330 CHURCH STREET, PARRAMATTA

ACCESS REVIEW

Morris-Goding Accessibility Consulting

4th May 2011

01 PLAN - LEVEL 00 (RETAIL)
1:200 @ A1

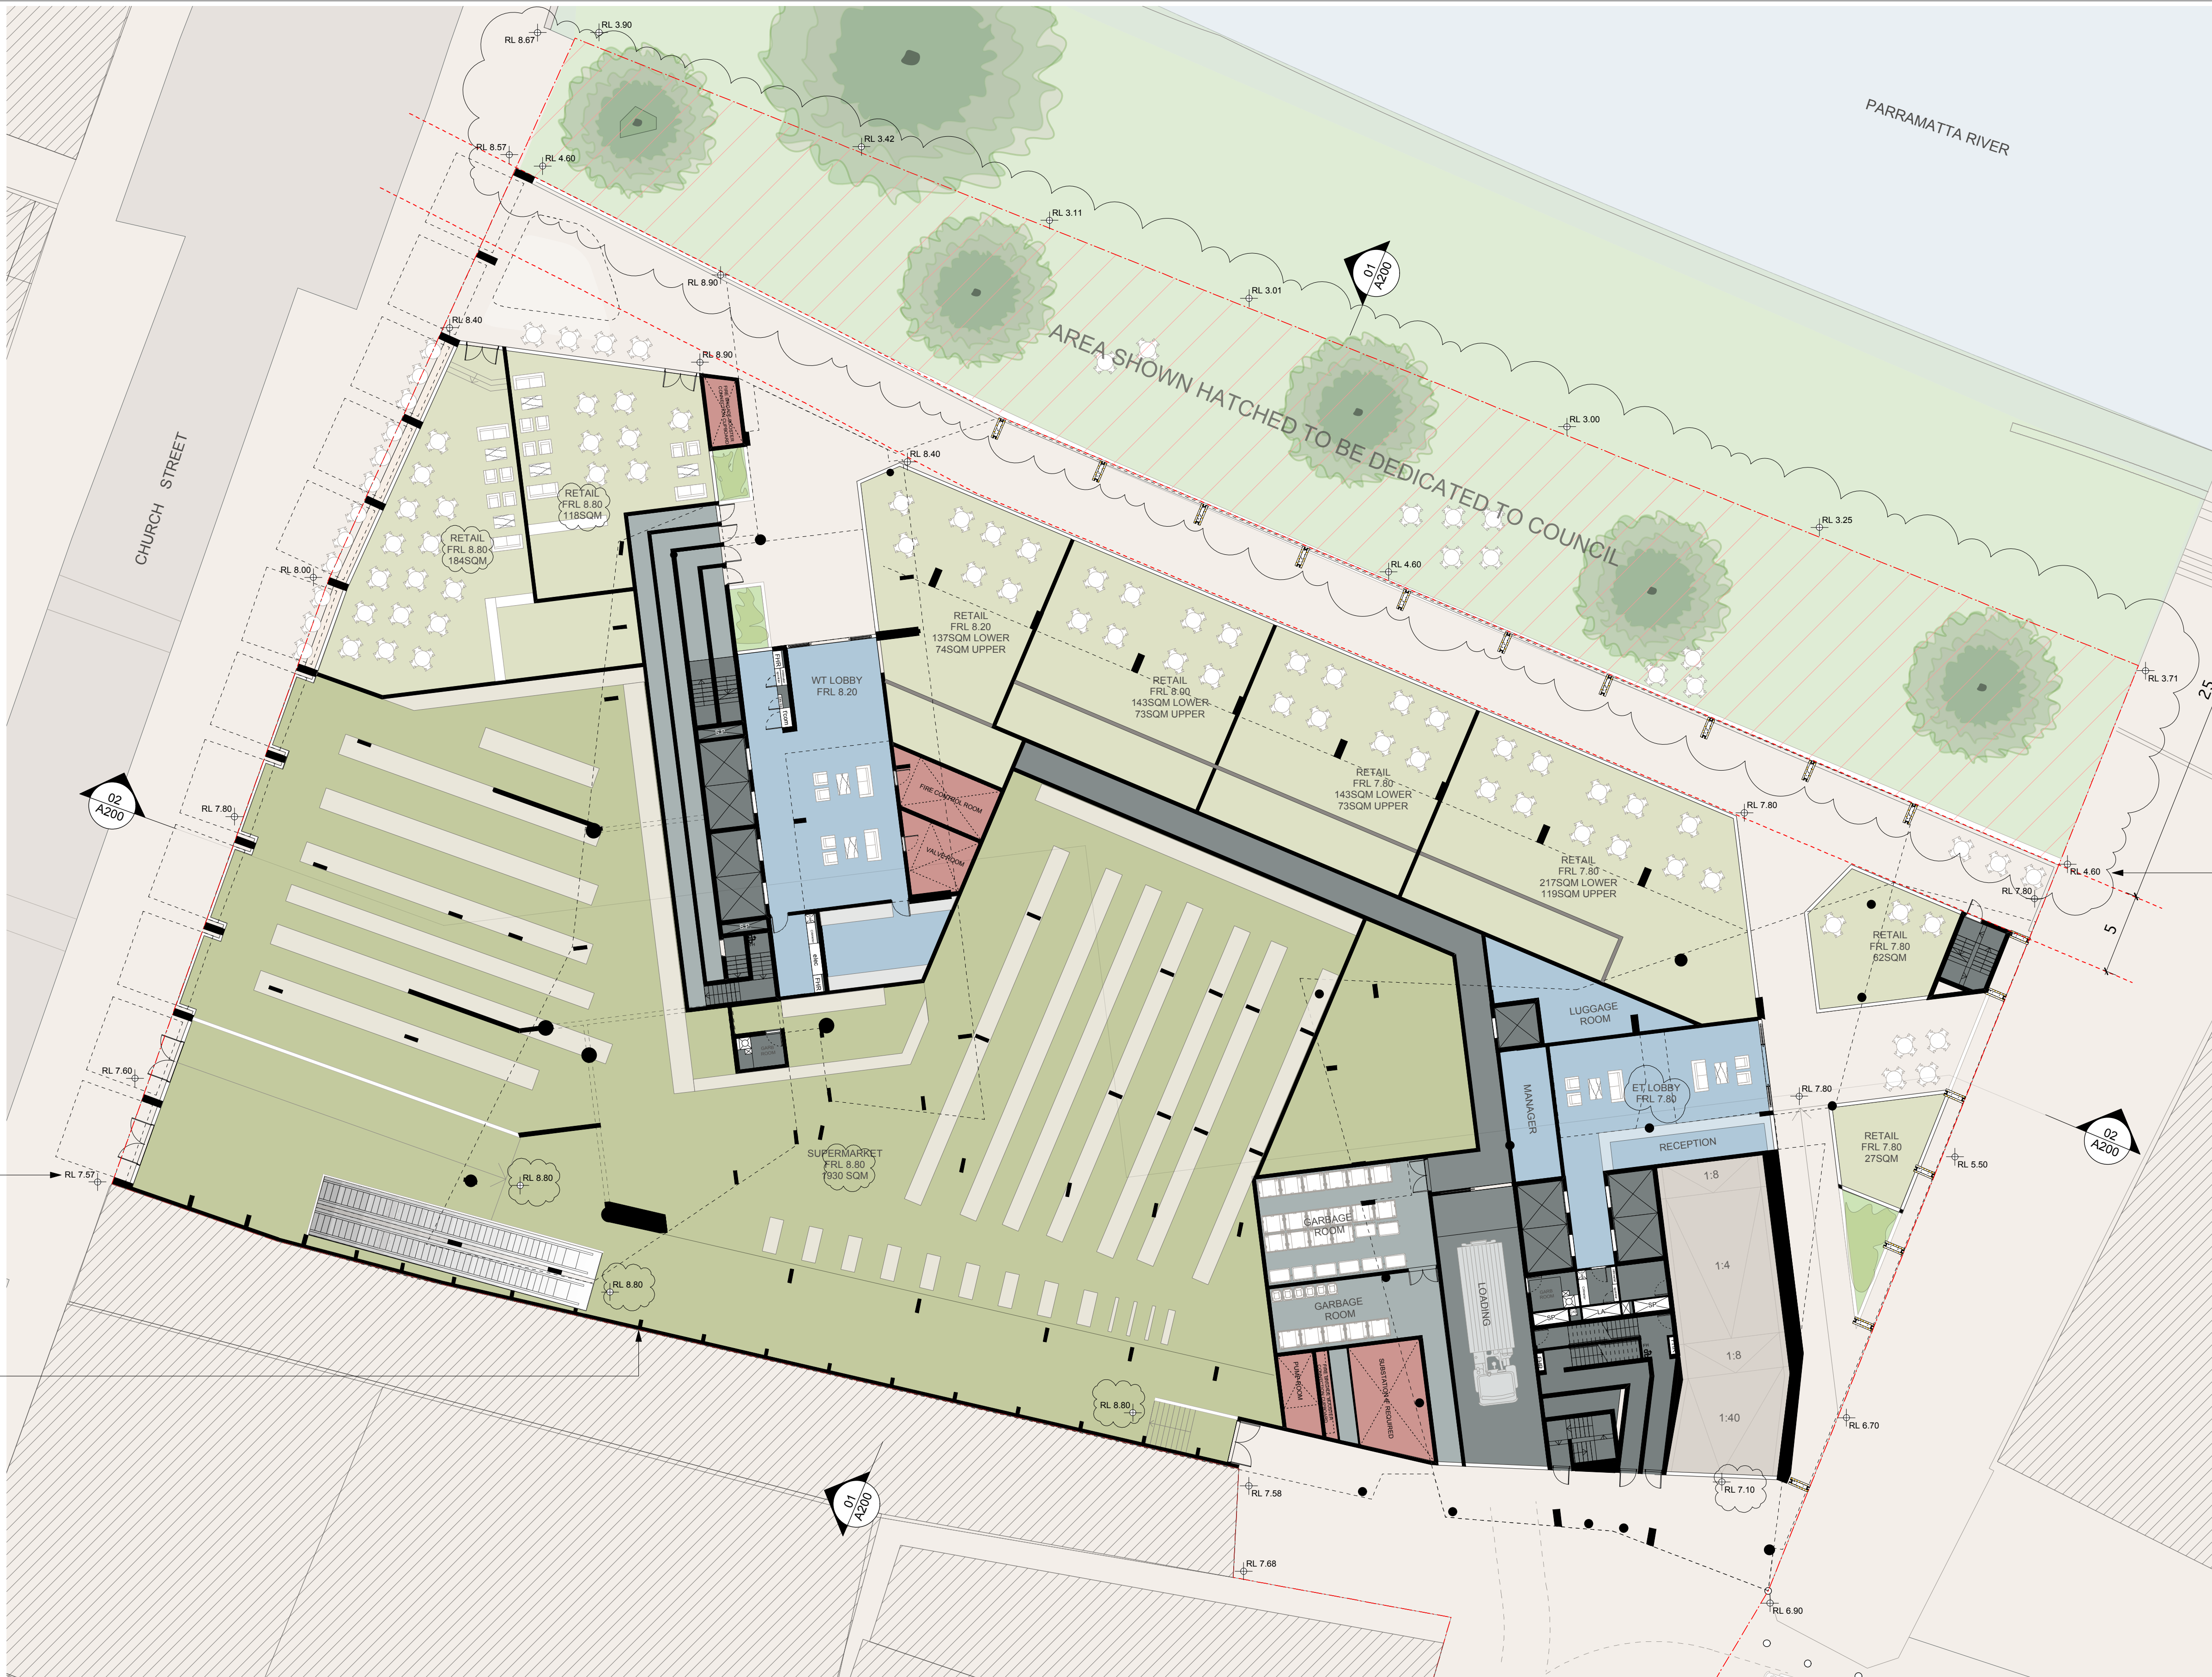
Entry into the Supermarket located on level 00 is via the pedestrian footpath near Church Street. There is appropriate clearance at the Church Street frontage for an AS1428.1:2009 compliant entry.

- (i) Ensure Supermarket entry doors have a min. 850mm clear width (920 door leaf) to comply with AS1428.1:2009 and the Parramatta City Centre DCP.

There are 7 retail tenancies and a supermarket located on the ground floor of the site. There is an appropriate path of travel from Church Street and the colonnade area into the retail premises. Entry into the supermarket is via Church Street pedestrian footpath, compliant with AS1428.1:2009, clause 6.1.

- (i) Ensure retail tenancy doors have a min. 850mm clear width (920 door leaf) to comply with AS1428.1:2009.

The pedestrian links through the site provides an appropriate continuous accessible path of travel suitable for persons in a wheelchair compliant with AS1428.1:2009. There are escalators located near the entry of the Supermarket which provides access to the retail car parking on parking level 01.

The accessible path of travel for a person in a wheelchair from the retail parking to the Supermarket and retail areas appears to be via the East Building entry lift lobby (as mentioned in Section 3.2), which is not suitable under DDA.

- (i) A passenger lift is required adjacent the escalator to access the supermarket car parking. The residential lifts cannot be used for this purpose.
